Re: Planning Application M/19/20/HH - 27 Shrubbs Drive

This application is basically a resubmission of application M/64/19/PL and I object to the proposed development for the following reasons.

Drawing P02 January 2020 Scale 1:100 / 1:500 / 1:1250 @ A3
Planning Drawing - Roof Plan, Elevations, Block & Location Plan

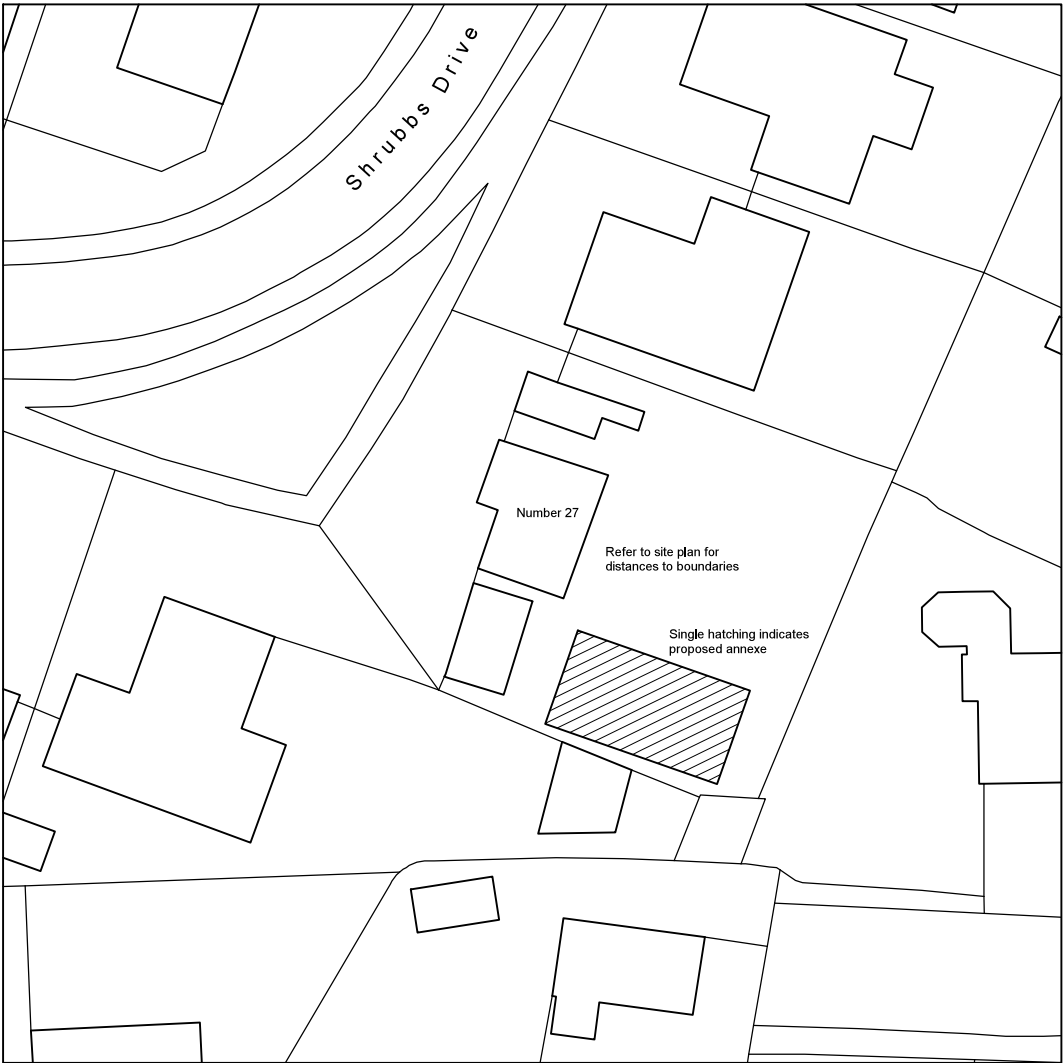
Plans P01 and S01 overstate the size and shape of the front garden of the property as can be seen in Plan P02
